Application Ref:	3/2026/0468			 Ribble Valley Borough Council www.ribblevalley.gov.uk
Date Inspected:	17/7/26	Site Notice:	17/7/26	
Officer:	BT			
DELEGATED ITEM FILE REPORT:				REFUSAL

Development Description:	Proposed erection of a two-storey self-build dwelling and associated annexe following demolition of existing workshop buildings.
Site Address/Location:	Healings Farm, West Bradford Road, Waddington, BB7 3JE.

Elevations as proposed 1:100 @ A3

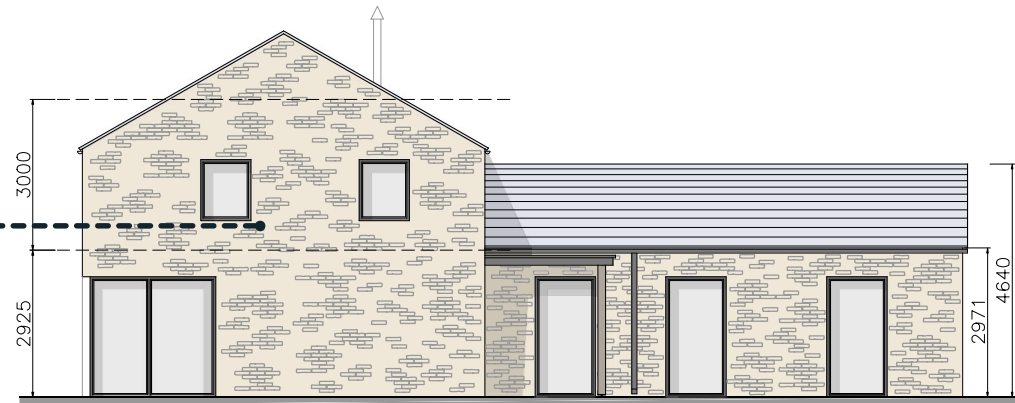
In contrast, whilst the proposed dwelling would comprise a similar footprint to the collective footprint of the single storey mono-pitched roof building and two nissen huts to be demolished, it would comprise a two storey component standing at 7.2m in height in comparison to the existing mono pitched roof building and nissen huts which comprise heights of 4.2m and 3.4m respectively. As such, the proposed dwelling, by virtue of its footprint, height, bulk and massing, would noticeably exceed the collective size of the buildings to be demolished and all of the other buildings within and around the application site by a considerable measure. Furthermore, whilst the proposed annex building would be comparatively modest in terms of its footprint and height, its addition to the site would nonetheless exacerbate the overall bulk and massing effect of the proposed development. Moreover, whilst the height of the dwelling's projecting gable components have been reduced to single storey elements relative to the design proposed for the dwelling refused under previous application 3/2025/0155, the dwelling's two storey component would nonetheless disrupt the existing descending roofscape of buildings within the application site, as shown on the proposed site section drawing submitted in support of the application.

Taking account of the above, it is considered that the proposed dwelling would read as a disproportionate, over dominant and incongruous addition to the application site in the context of the site's existing built form which in turn would be harmful to the visual amenities of the area. The proposed development would therefore fail to satisfy the requirements of Policy DP3 (1) of the NPPF (2026) and Policy DMG1 of the Core Strategy.

Furthermore, the proposed dwelling, by virtue of its footprint, height, bulk and massing, would read as a disproportionate, over dominant and incongruous addition to the application site in the context of the site's existing built form which in turn would be harmful to the visual amenities of the area. Moreover, it is not considered that a viable fallback position exists to justify the visual harm that would arise from the development proposed under this application. The proposed development would therefore fail to satisfy the requirements of Policy DP3 (1) of the NPPF and Policies DMG1 and DMG2 of the Core Strategy.

| 02: | The proposed dwelling, by virtue of its footprint, height, bulk and massing, would read as a disproportionate, over dominant and incongruous addition to the application site in the context of the site's existing built form which in turn would be harmful to the visual amenities of the area. Moreover, it is not considered that a viable fallback position exists to justify the visual harm that would arise from the development proposed under this application. The proposed development would therefore fail to satisfy the requirements of Policy DP3 (1) of the NPPF (2026) and Policies DMG1 and DMG2 of the Ribble Valley Core Strategy. |
